Application H03-0908-19
Location Caultons Field west: Littleworth Drove Deeping St Nicholas PE11 3AE
Proposal Details of Interpretive Report on Ground Investigation Report (Condition 11 of H03-0331-16)

I have reviewed the Nicholls Colton Group 'Interpretative report on a ground investigation for a proposed residential development on land off Littleworth Drove, Deeping St Nicholas, Lincolnshire' report no. G19202-IR dated August 2019. It is not possible to recommend discharge of condition 11 of H03-0331-16 at the current time.

Title:
Exploratory Hole Location Plan.

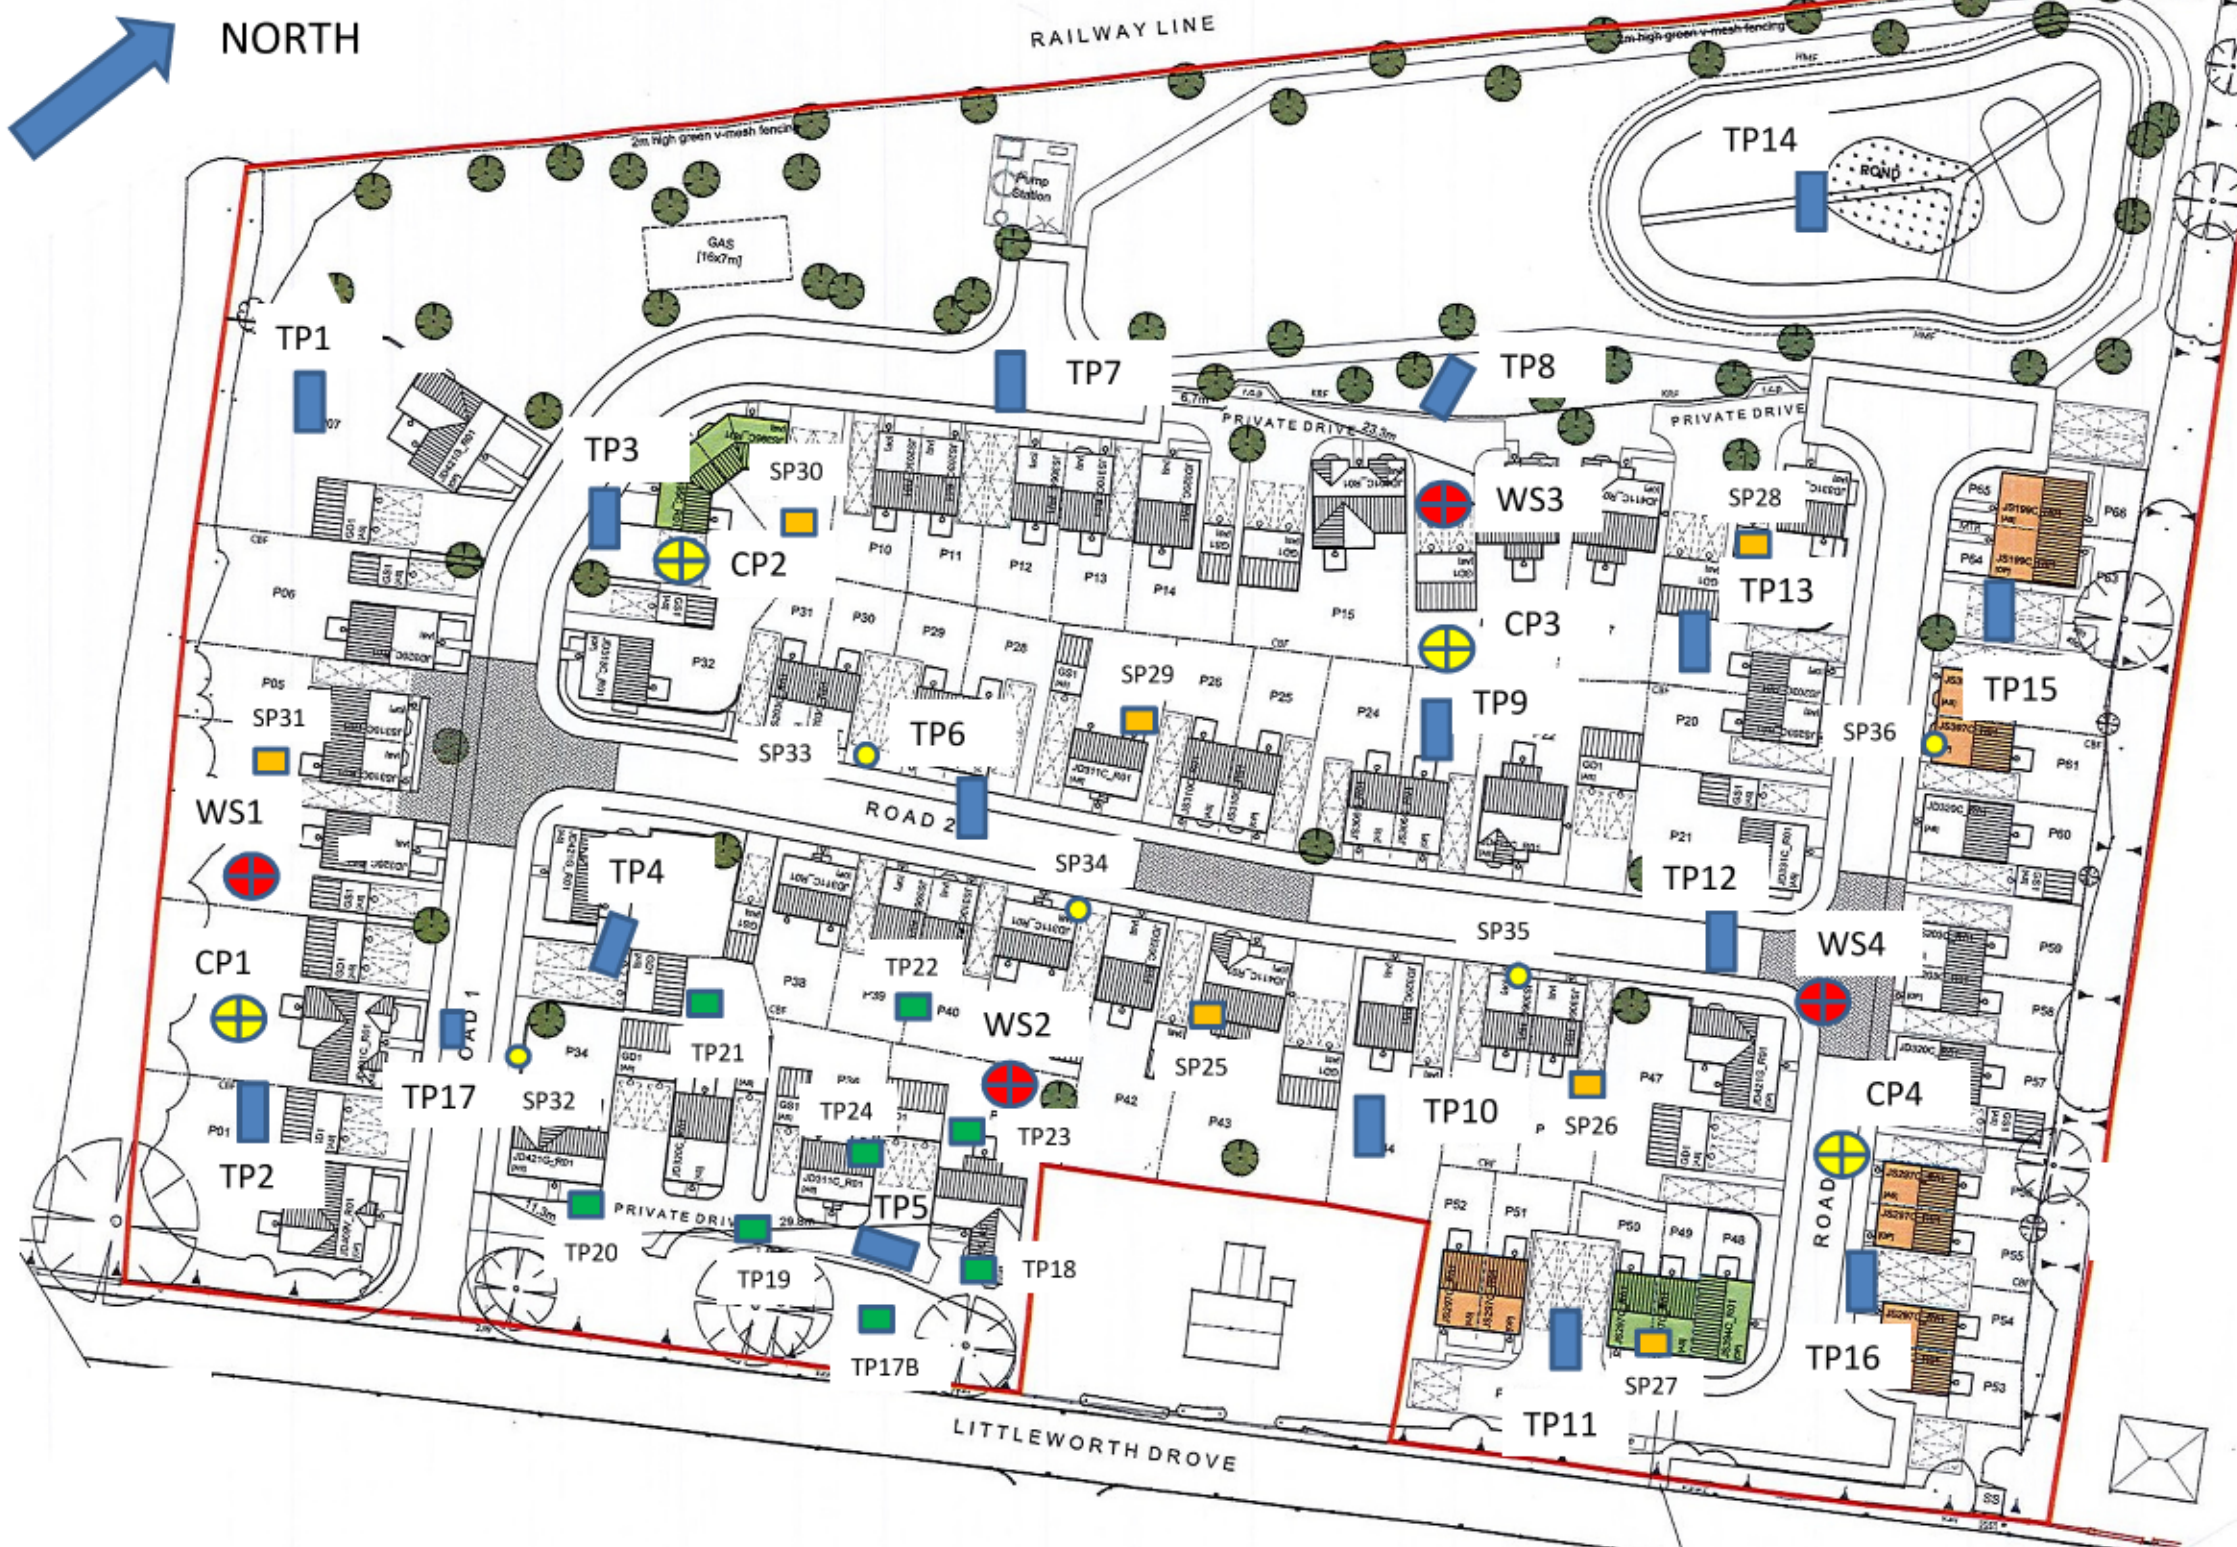
- Further consideration should be given to the extent of made ground identified in TP5.

Looking at the historical mapping the layout is synonymous with that of many farms in the area. Should the area of made ground be significant then further chemical analysis will be required to support the conclusion that the elevated PAH fractions are 'marginal and localised'.
